TO: All Staff
FROM: Public Works Planning Review Team
DATE: March 9, 2021
SUBJECT: BL-20-00032 Evergreen Valley

The Public Works Department has reviewed the Request for Boundary Line Adjustment Application. In order to ensure that it meets current Kittitas County Road Standards, the applicant needs to provide the following prior to final approval:

BOUNDARY LINE ADJUSTMENT BL-20-00032

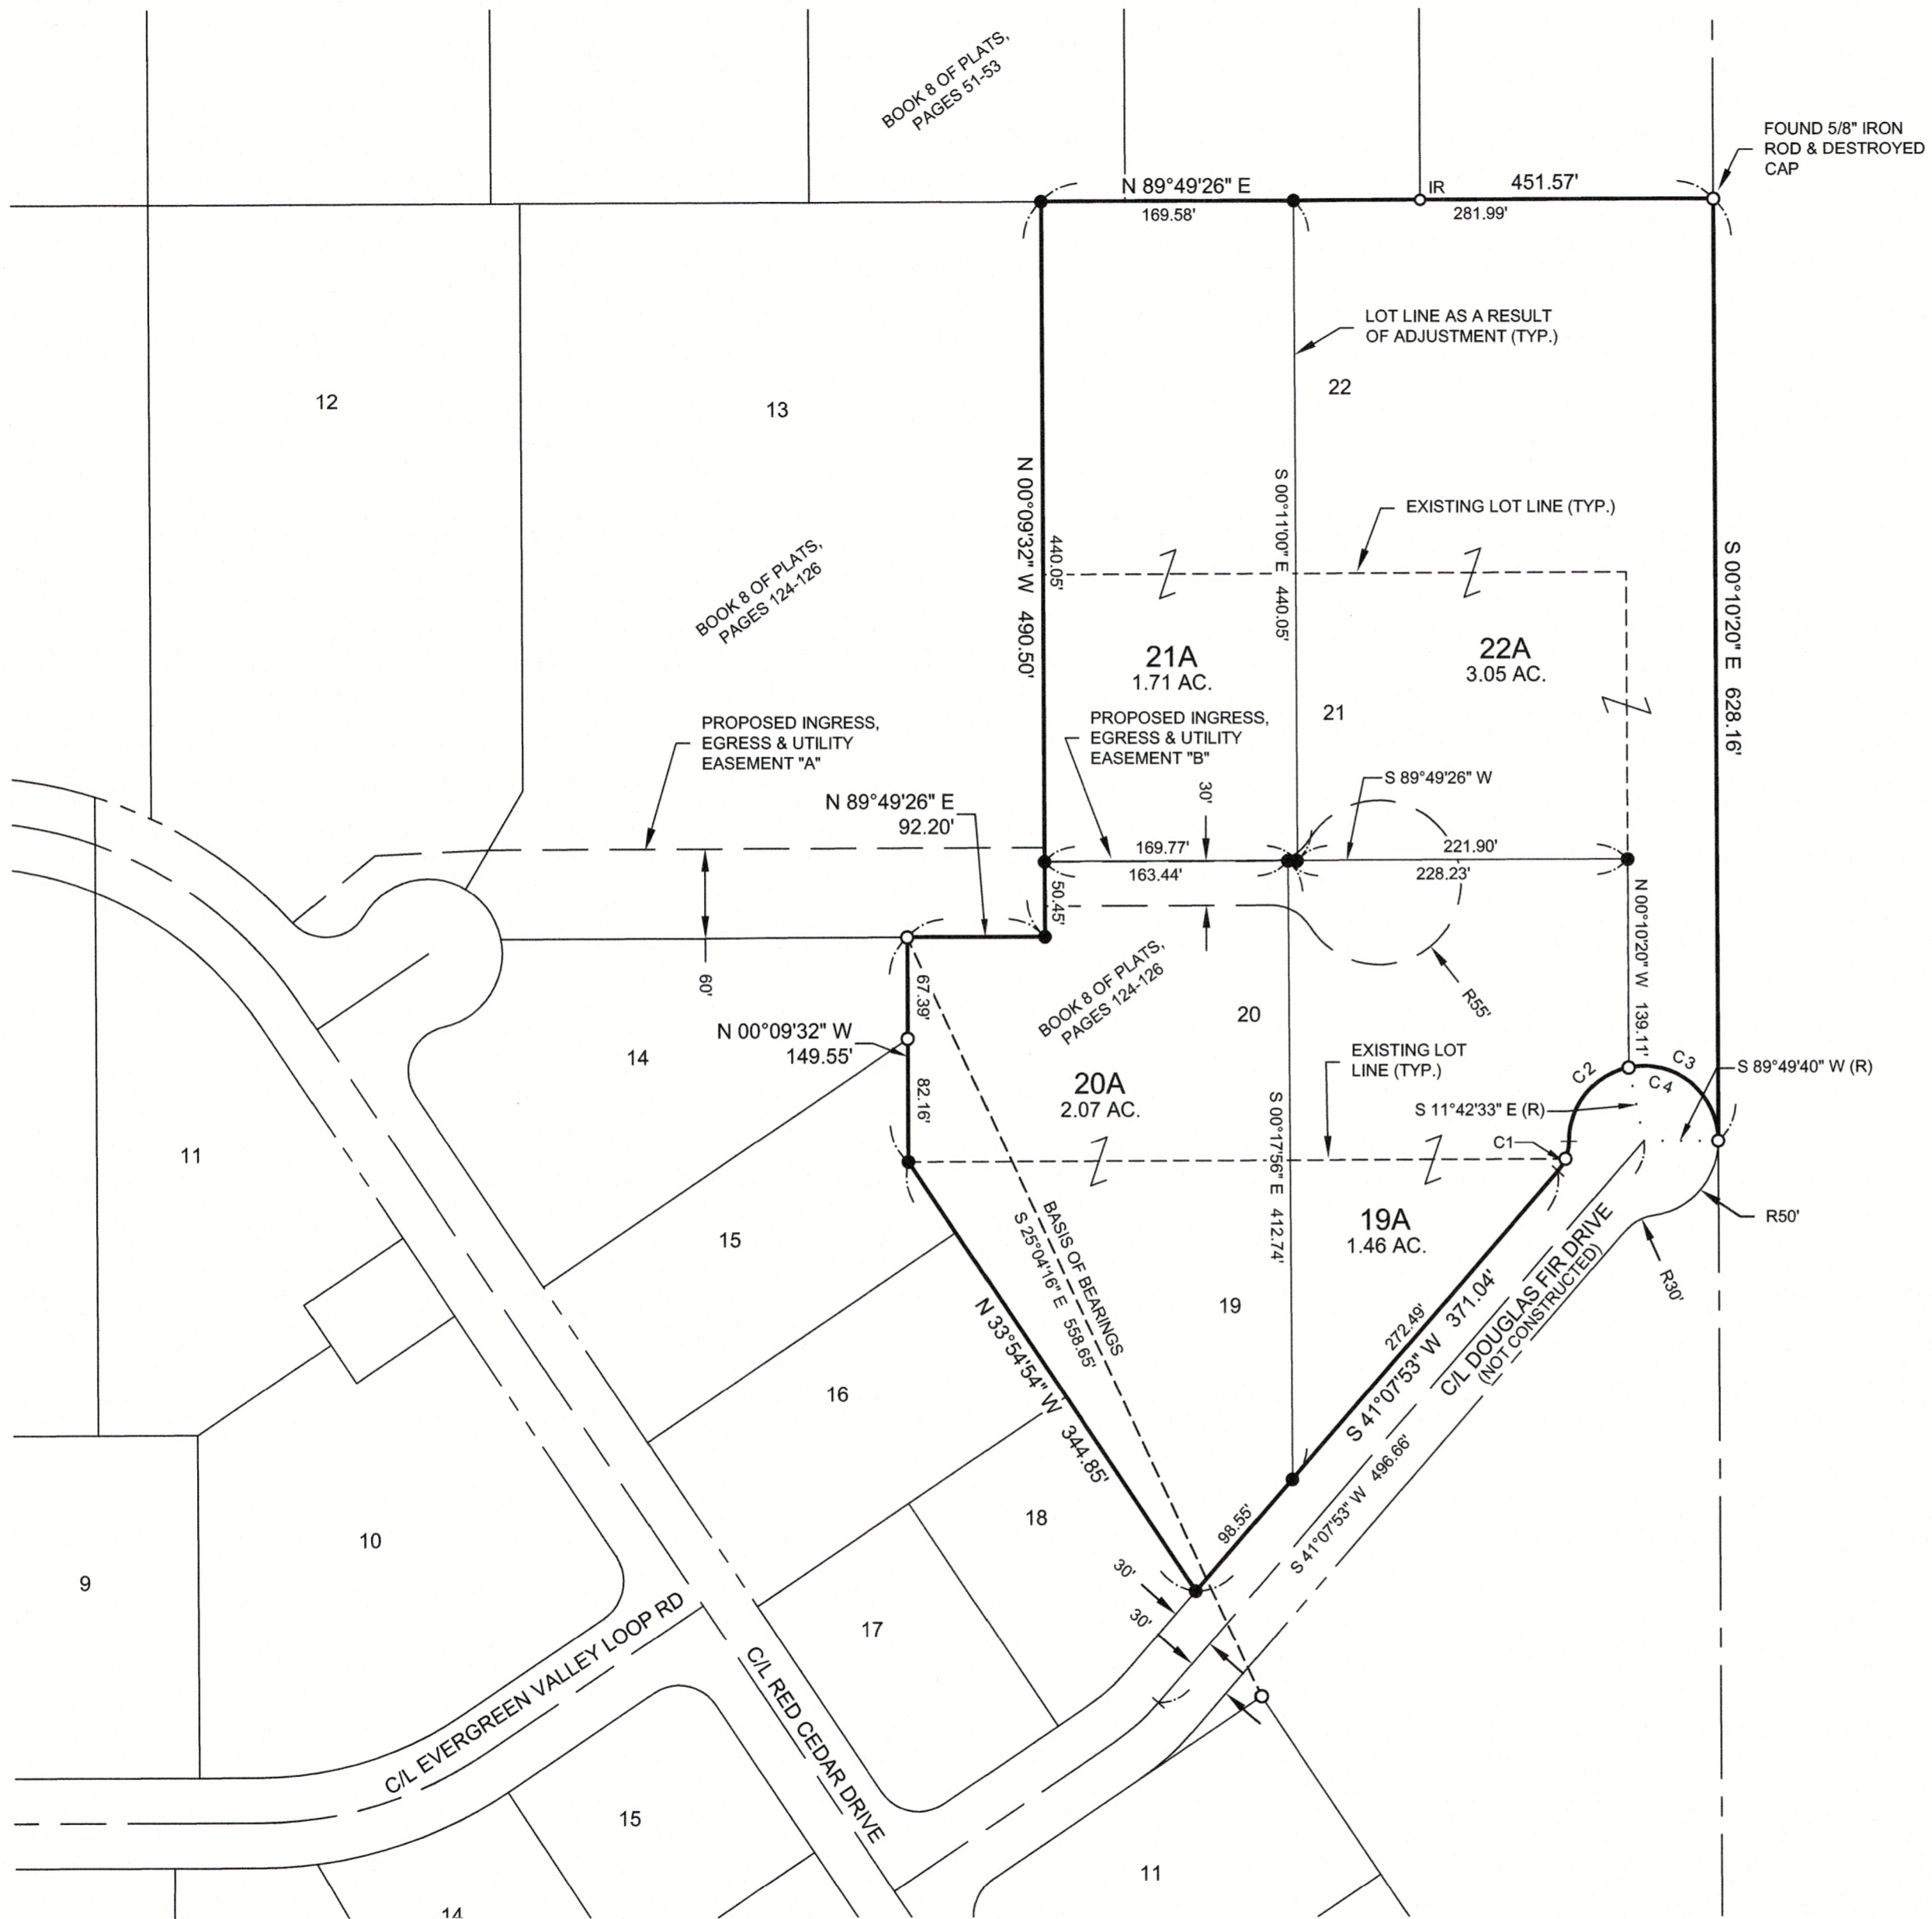
1. The proposed ingress, egress & utility easements "A" and "B" on the preliminary survey provide adequate access to all lots on the application. Please provide Public Works with the recorded easements as proof of access to these lots.

1. Until such time as the proposed ingress and egress easements are recorded, Lot 21 A remains landlocked. I would propose waiting until Easement A is recorded PRIOR to recording of the BLA. Alternatively, a temporary access easement could be created over and across the lands involved in the BLA to serve as an access until such time as the Proposed access is finalized.
2. If the intent of the Access easements is to reference this BLA for the mathematical position of the easements, it should be notes, that neither Easement A or B is retracable from the given information.
